One Carrington SSD and Concept Plan (Mod 2)

Attachment A - Response to Department's Key Issues

Comment	Response
CONCEPT PLAN MODIFICATION (MP09_0076 MOD2)	
Public Benefits	
1. The current proposal amends the proposed Transit Hall and includes additional floor space and 285 George Street. The following additional information is required:	See below.

ONE CARRINGTON STREET
SWEPT PATH ASSESSMENT
AUSROADS 8.8m MRV
ACCESSING EXIT RAMP

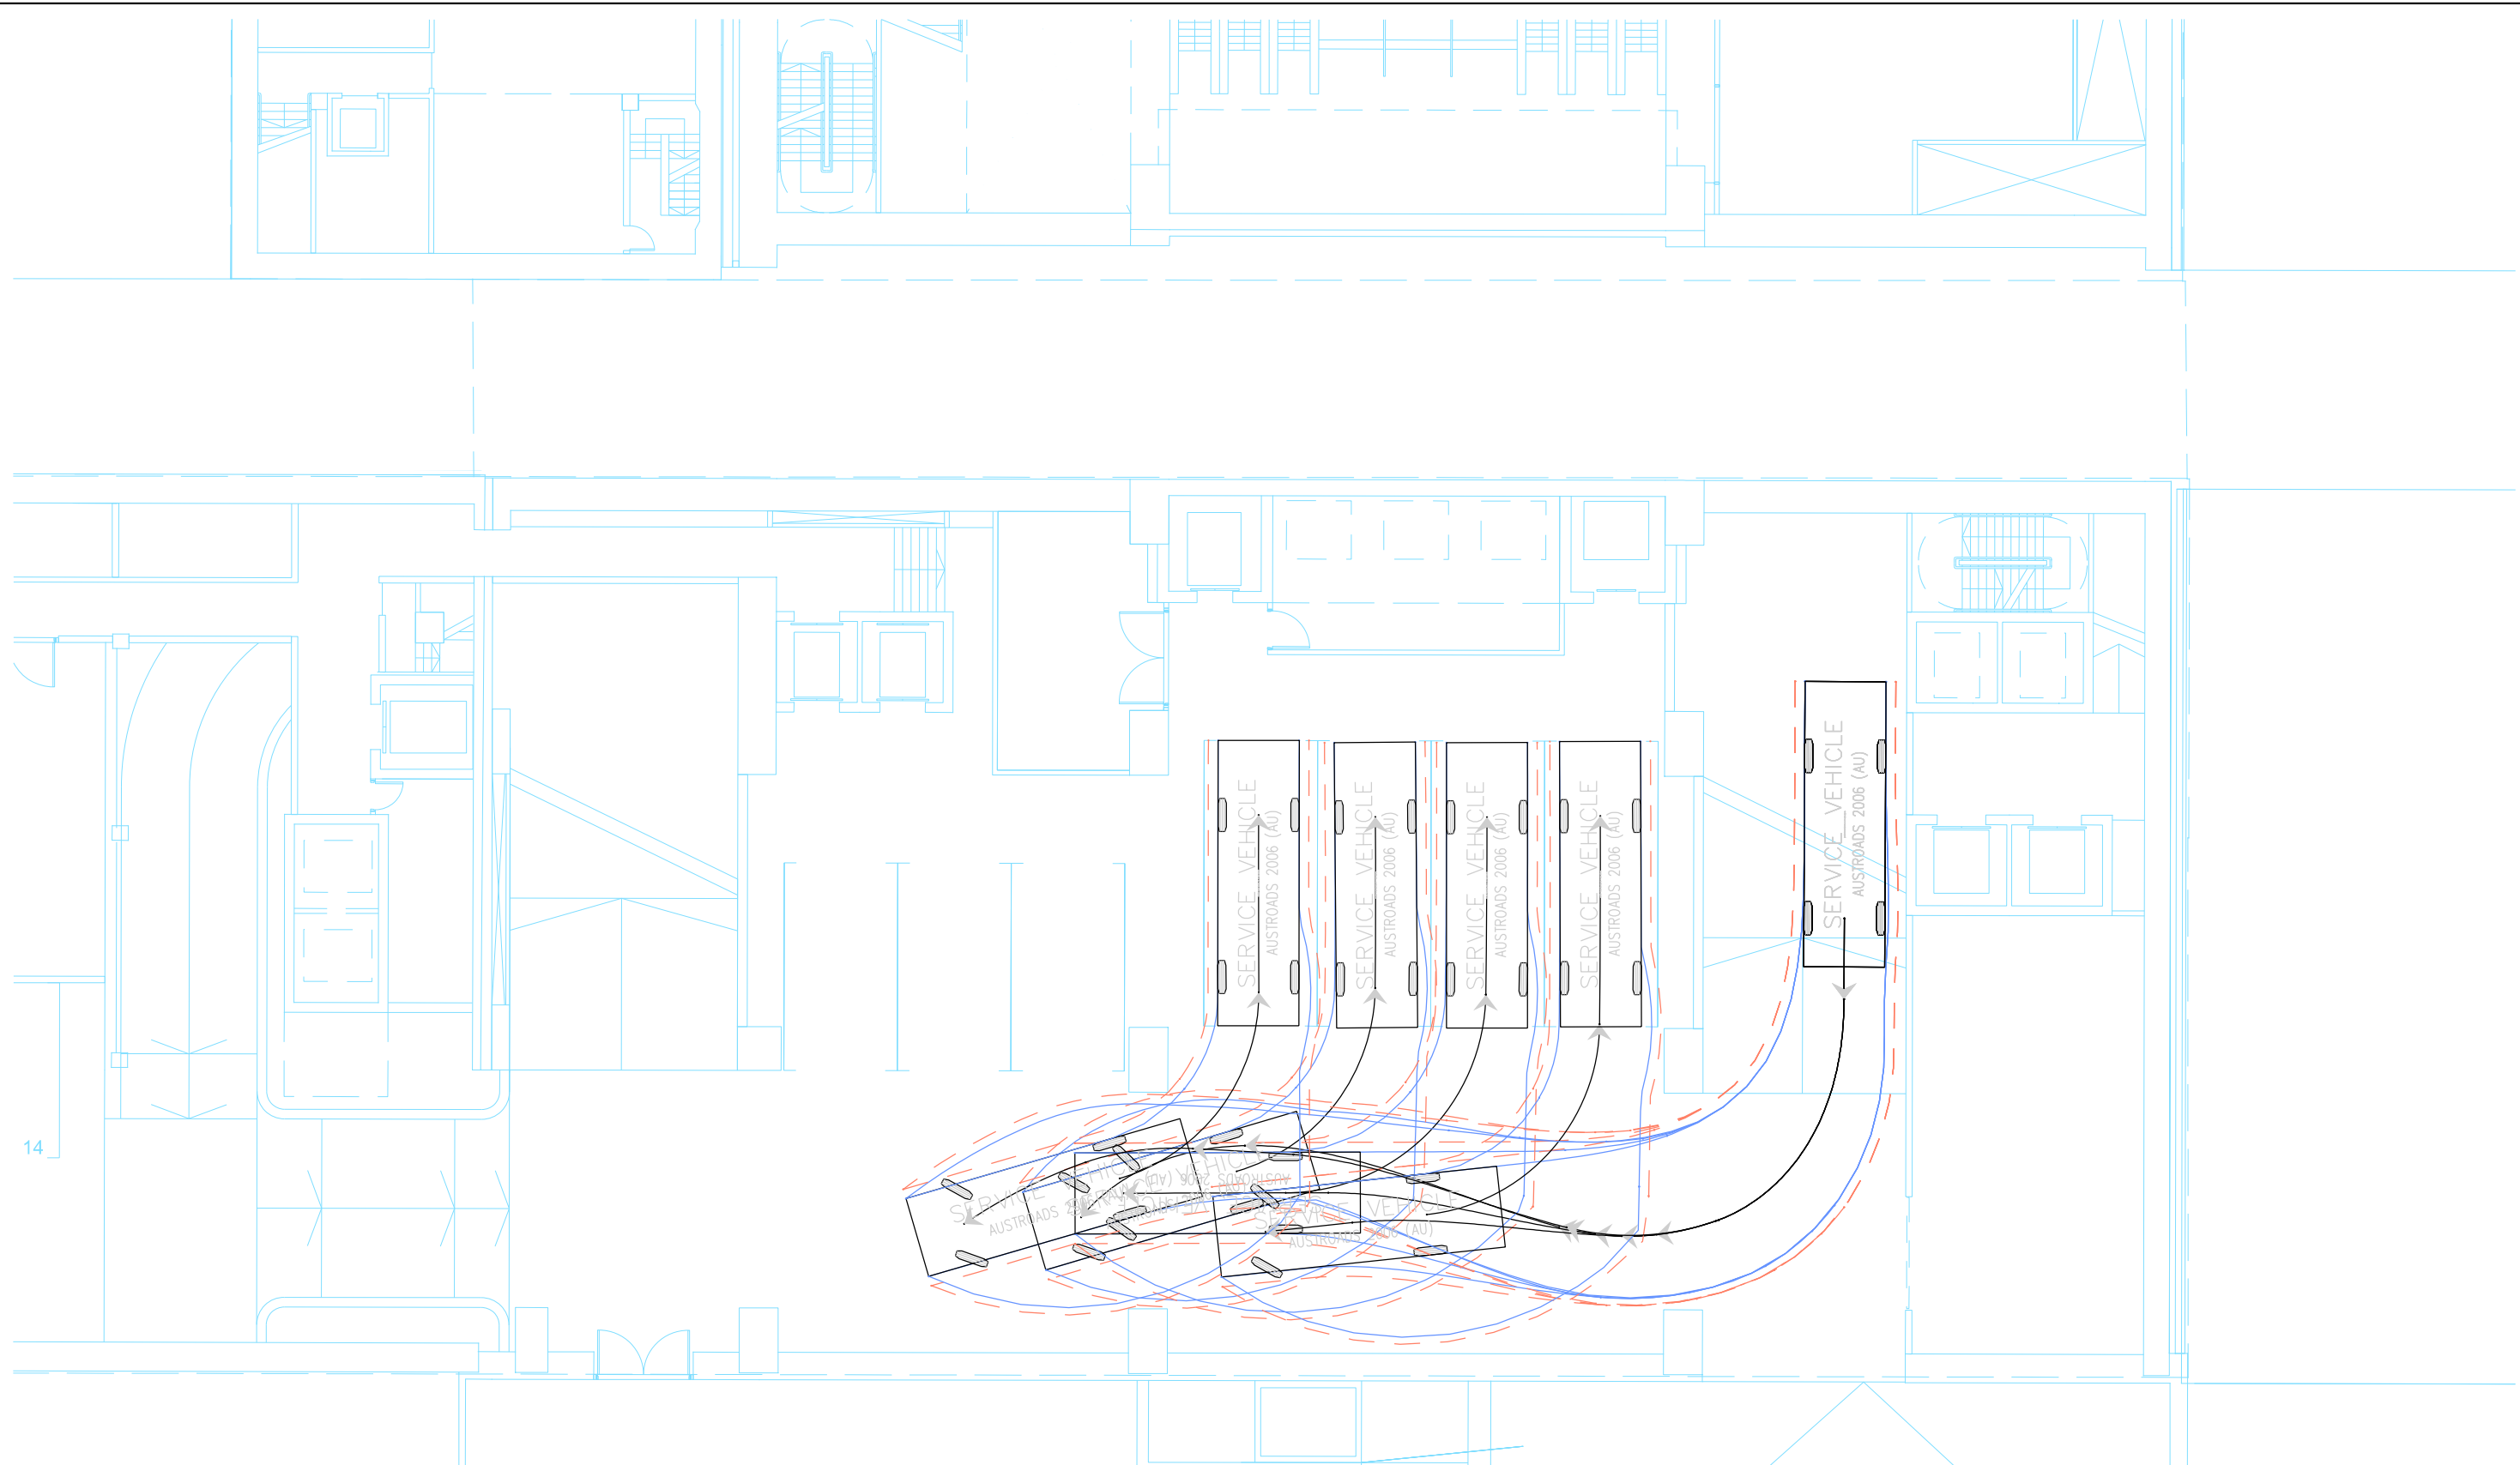
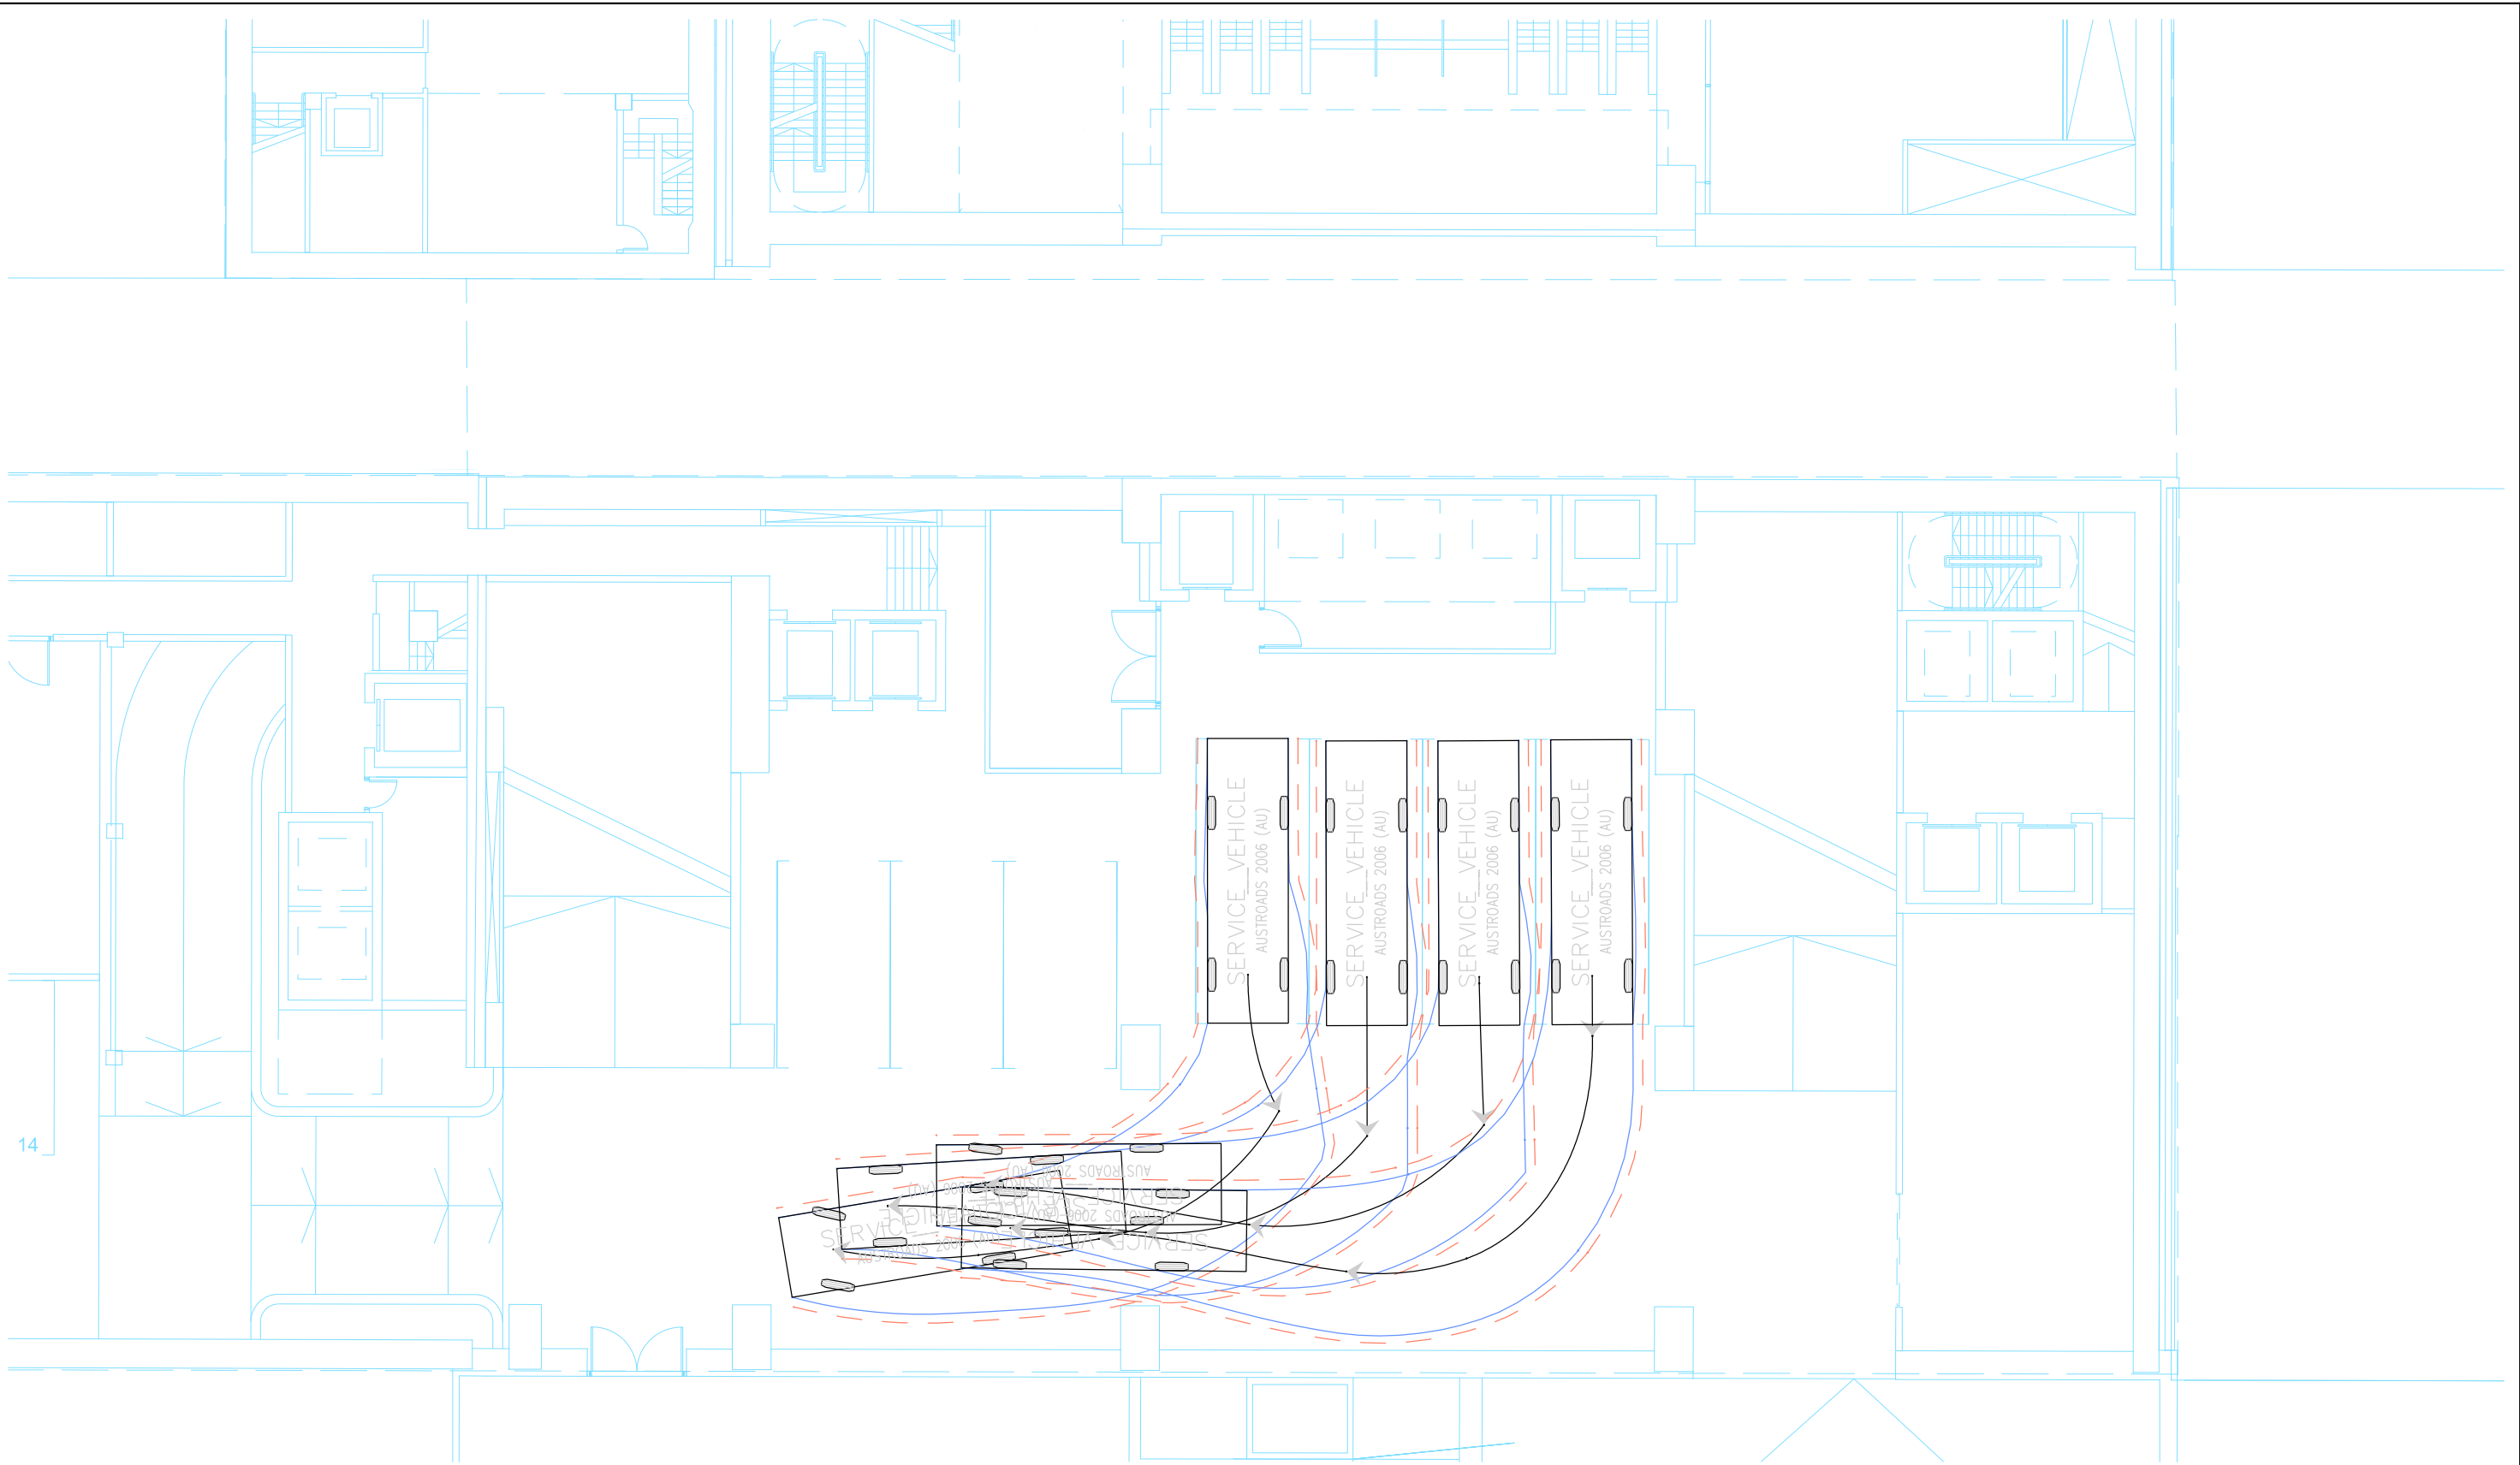
a. vehicle swept path analysis confirming that:	An analysis prepared by GTA Consultants (GTA) regarding the detailed issues raised under each of these sub-points is located in Attachment G . This vehicle swept path analysis confirms <i>service vehicles can enter and exit from the proposed loading dock and basement car park entry/exit points from Wynyard Lane; the proposed loading bays can be accessed in a reasonable manner; and the 'one-way aisle' providing access to the loading bays can accommodate necessary vehicle manoeuvres</i> . We trust the attached information sufficiently responds to these matters

i. service vehicles can enter and exit from the two proposed loading dock and basement car park entry/exit points from Wynyard Lane;	
ii. the proposed loading bays can be accessed in a reasonable manner ; and	
iii. the 'one-way aisle' providing access to the loading bays can accommodate necessary vehicle manoeuvres .

12. The following additional information is required regarding the access to and operation of the basement level servicing area:	The loading dock has been designed in accordance with the Australian Standard. A swept path analysis has been provided at Appendix S of SSD submission that confirms that there would be no issues with vehicle turning geometry for vehicles up to an 8.8m MRV.
